Date: 24th October 2014

Your Ref. AW/213/14/PL

Re Application AW/213/14/PL To Build a Detached Bungalow Within the Boundary Of No. 4. Peterhouse Close, West Meads, Aldwick, West Sussex adjoining No. 6.

Existing floor plan
No. 4 Release Close

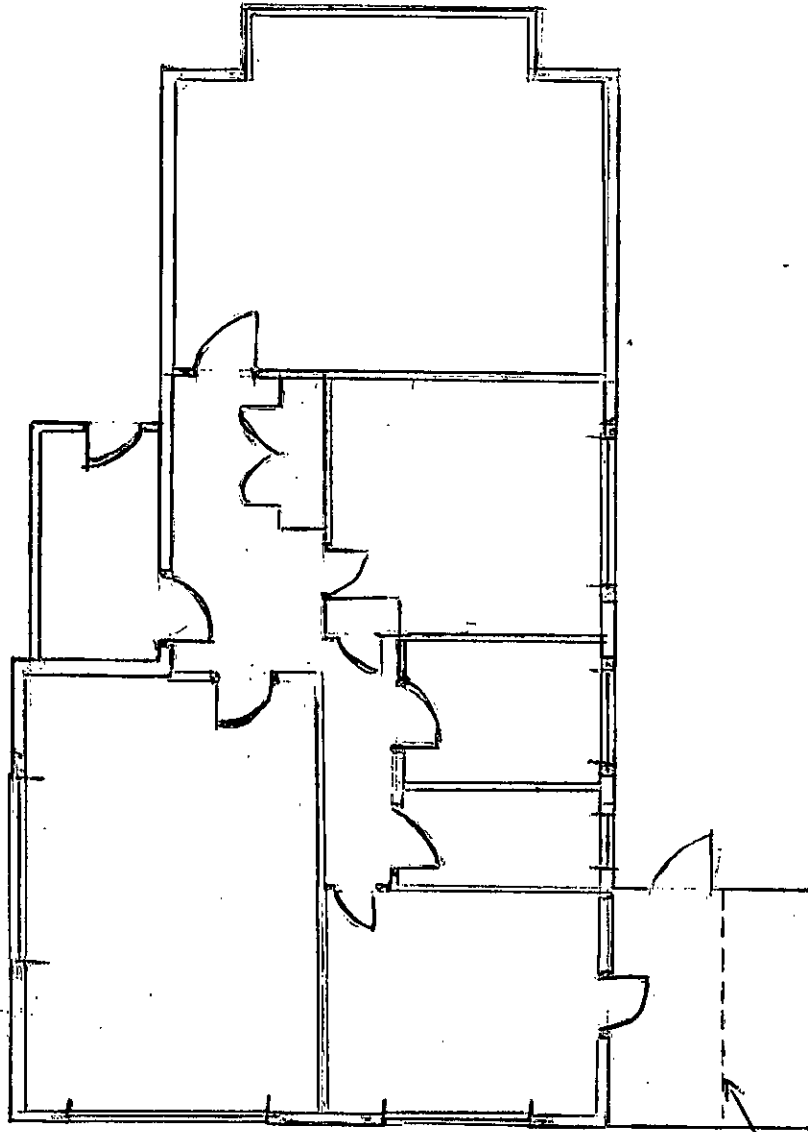
The lean to as shown on the plan (to be reduced in size) should be removed to allow full access to the properties for emergency services (fire service) if approved.

1:100 Proposed Drawing. 006

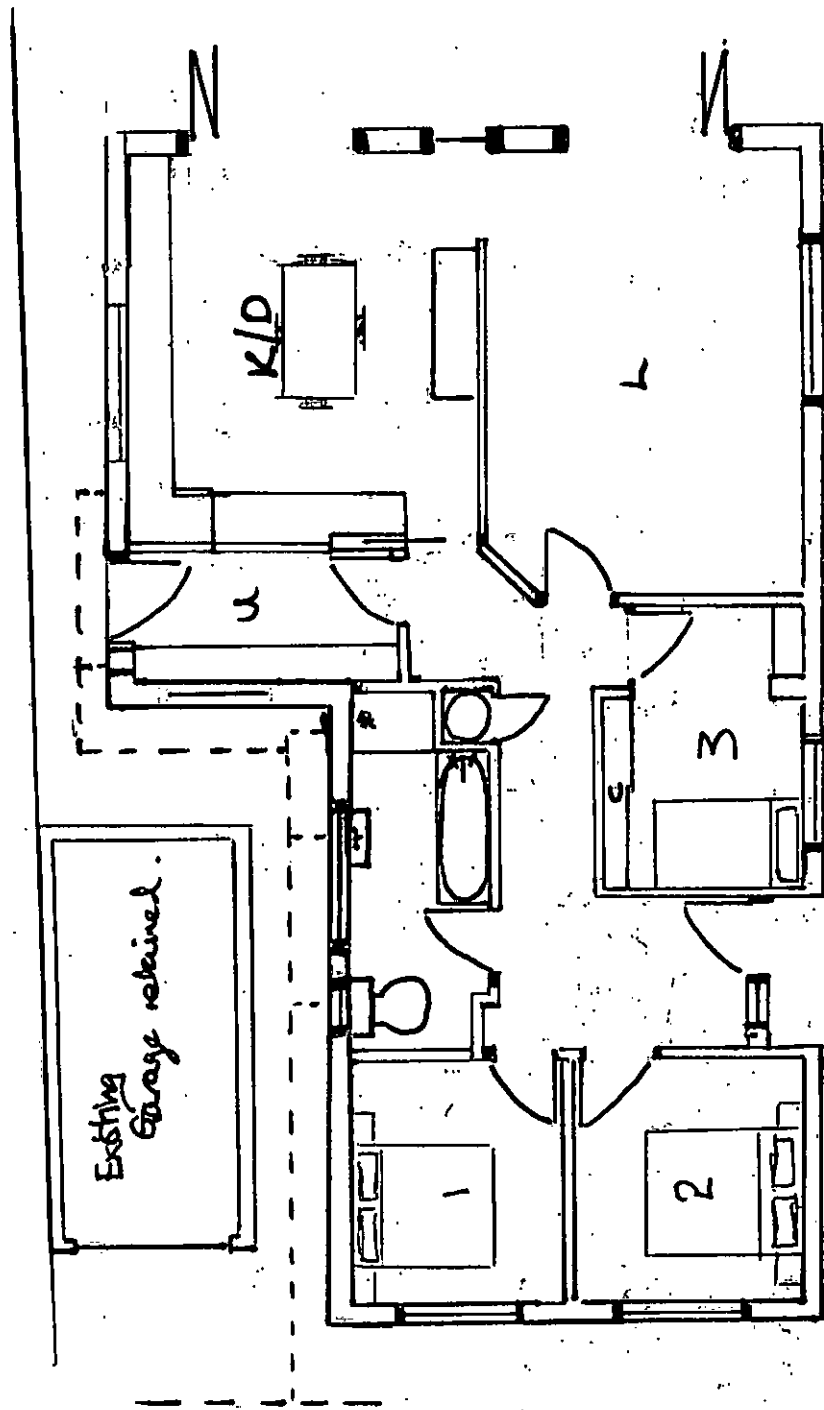
The front of the proposed bungalow No.4A would appear to be in front of the building line of No.4.

The new garage to the front of No.4. encroaches on the front grassed areas of the street.

The distance between the two properties No.4 and no.4A and no.6 would appear to be very tight, leading to the site line boundaries being encroached upon including the guttering.
